Submission Form

Epping to Thornleigh Third Track Proposal. Application number SSI 5132.

Figure S.5 Artist's impression of new elevated concourse at Cheltenham Station looking south from The Crescent (indicated by dot)

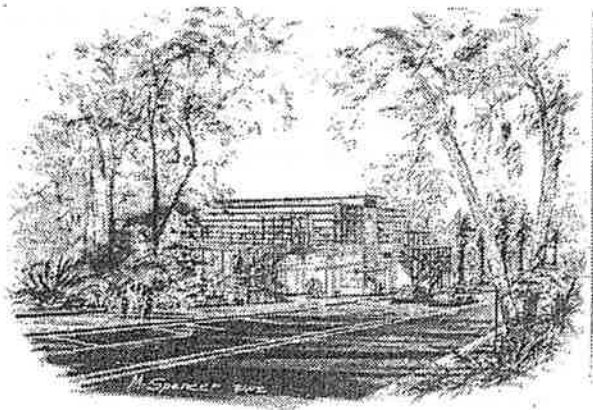
- The proposed redevelopment of Cheltenham Station shows no regard for the HCA. The visual impact of the proposed 13m high glass and steel concourse is totally unacceptable in this HCA.
